London Luton Airport Expansion

8.76 Applicant's response to Written Questions - Historic Environment

Application Document Ref: TR020001/APP/8.76

**8.76 APPLICANT'S RESPONSE TO WRITTEN QUESTIONS –
HISTORIC ENVIRONMENT**

Drawing Title
Figure 10.8 Designated Heritage Assets Change in 2043 Do-Something - Do-Minimum Daytime LAeq,16h Air Noise Contours

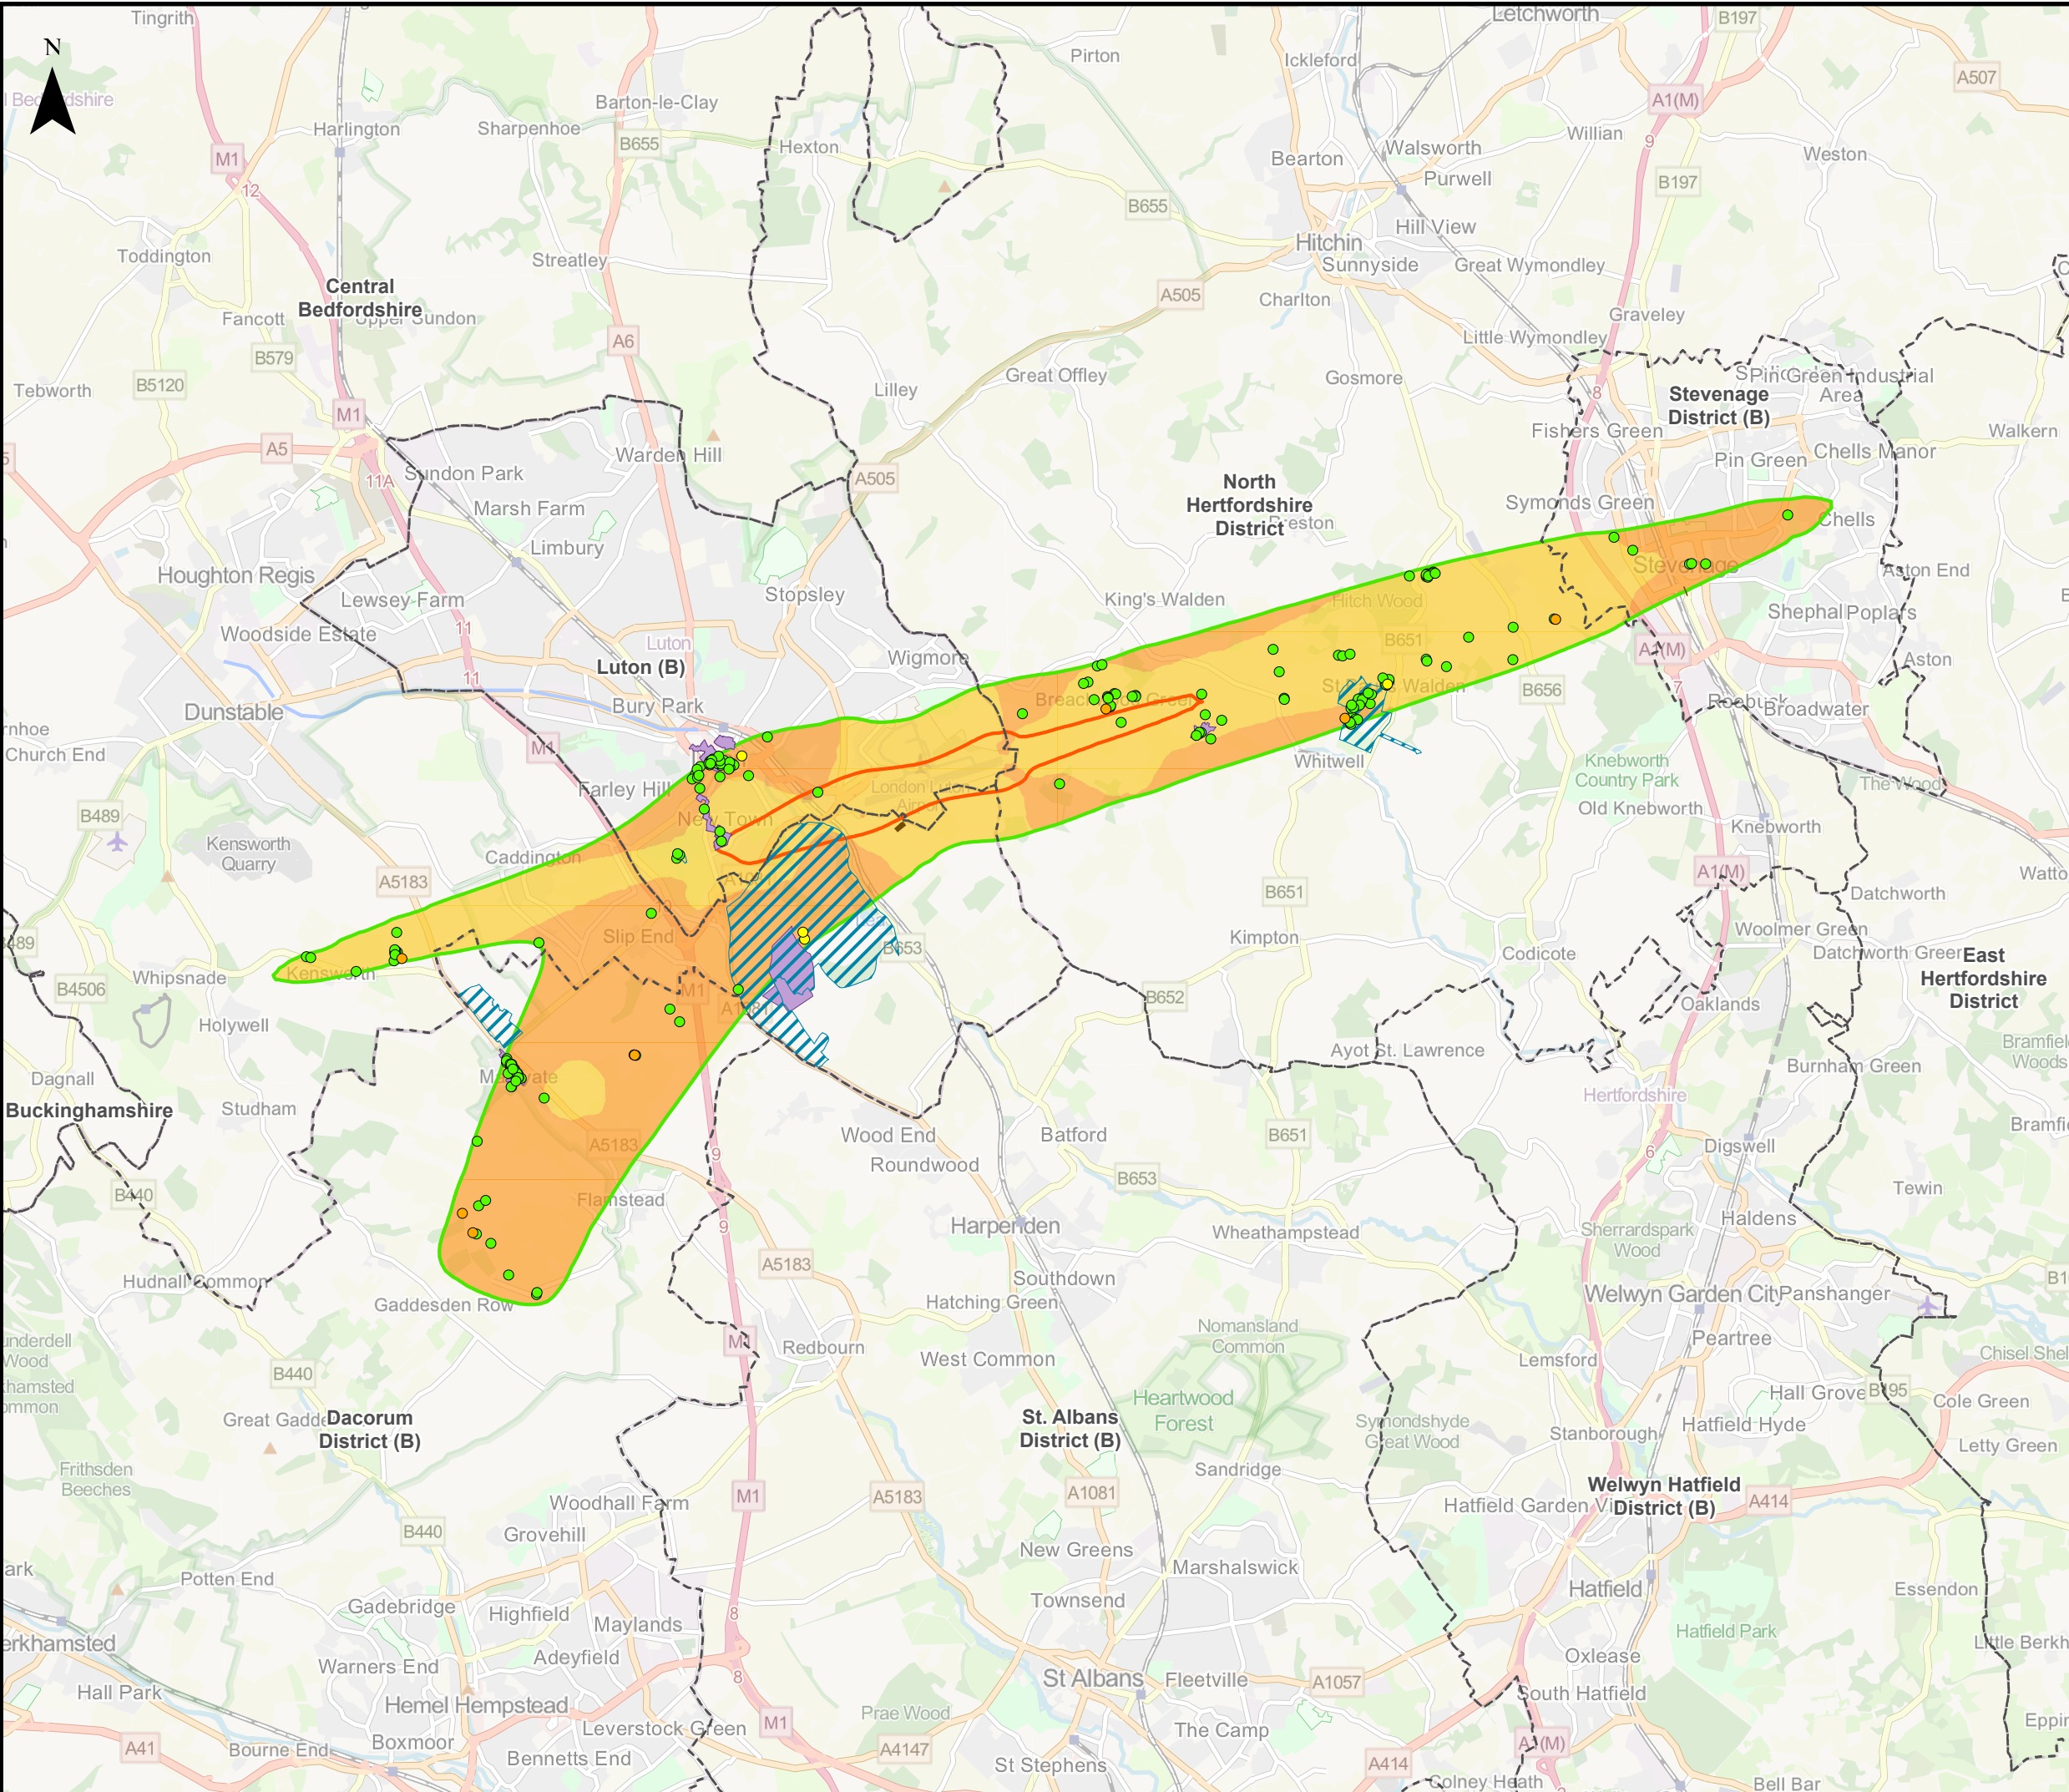
PED.1.12	<p>Question: Impact Assessment for St. Paul's Walden Bury Grade I listed Registered Park and Garden (RPG)</p> <p>Chapter 10 of the ES [AS-077, paragraph 10.9.88] states that the noise change contours for assessment Phase 2a and assessment Phase 2b operation [APP-150, Figures 10.7 and Figure 10.8] show an increase from the future baseline of between 1dB and 1.9dB above 51dBLAeq,16h but below 63dBLAeq,16h where this would be a negligible change to the park's noise environment. Looking at Figure 10.8, at Phase 2b it appears that parts of the park would represent a change of between 2dB and 2.99dB.</p> <p>Please confirm if this is correct and if so, provide any updates to the assessment in Chapter 10 of the ES.</p> <p>Response: Chapter 10 of the ES [AS-077, paragraph 10.9.88] states that the noise change contours for assessment Phase 2a and assessment Phase 2b operation would increase from the future baseline between 1dB and 1.9dB resulting in a negligible change to the park's noise environment. This reflects the situation across the majority of the asset The Applicant acknowledges that the change in predicted noise levels does vary within the St Paul's Walden Bury Registered Park and Garden with some areas experiencing a change of between 2dB and 2.99dB during Phase 2b [APP-150, Figure 10.8].</p> <p>The change in noise identified during Phase 2b will affect the southern section of the park. As noted in Chapter 10 of the ES [AS-077] paragraph 10.9.86, the baseline noise environment changes in the southern part of the park where the farm buildings are part of a working farm. Aviation noise from overhead aircraft approaching the airport is part of the asset's noise environment but the noise does not intrude to such an extent as to detract from the asset's rural character.</p> <p>The noise increase during assessment Phase 2b would arise from the increased frequency of flights. The noise environment within the park is not a quiet experience and does not rely solely on quietness for an appreciation of its heritage interests. The noise change contours for assessment Phase 2a and assessment Phase 2b operation (Figure 10.7 and Figure 10.8 of the ES [APP-150]) show an increase from the future baseline of between 2dB and 2.99dB above 51dBLAeq,16h but below 63dBLAeq,16h. This would be a negligible change to the park's noise environment and would not affect its setting or impact its heritage value. This is therefore assessed as no impact and no effect. Despite the increase in noise levels, the effect on the asset remains the same as reported in Chapter 10 of the ES [AS-077].</p>
